Permit Number: 041757

This is to certify that 424 Warren Avenue Lic /James Spinelli
has permission to Auto Repair Shop / install 2 x 8'1" signs *no sign approval with James Spinelli*
AT 429 Warren Ave 304 B032001

City of Portland, Maine - Building or Use Permit Application

Dept: Zoning **Status:** Approved with Conditions **Reviewer:** Marge Schmuckal **Approval Date:** 12/02/2004

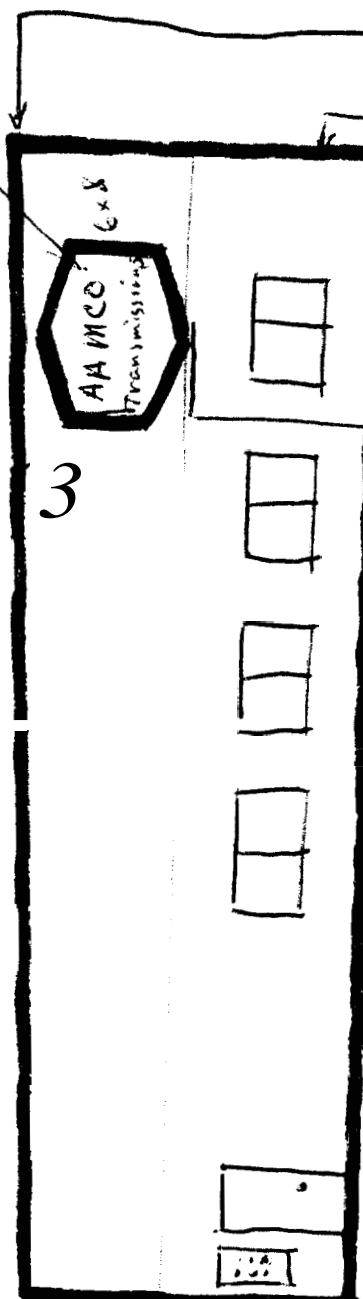
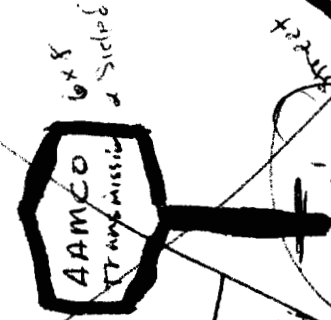
- 1) It is understood that the proposed freestanding sign is withdrawn from this application. It is considered to be a 2nd free standing sign which is not permitted by ordinance. This approval is only for the proposed sign attached to the building.

Wall Mounted on Side of Building
 Withdrawn by owner
 James Spinecci
 12/2/04

2nd free standing sign
 NOT PART of
 This permit
 Approved Pole
 4' below ground

- 1) Permit approved based on the plans submitted and reviewed w/owner/contractor, with additional information as agreed on and as noted on plans.
- 2) Signage Installation to comply with Chapter 31 of the IBC 2003 building code.

Two Bolted 3/4" x 8"
 Sheet metal / steel studs
 into 2x6 & structural
 steel
 per James Spinecci
 12/21/04
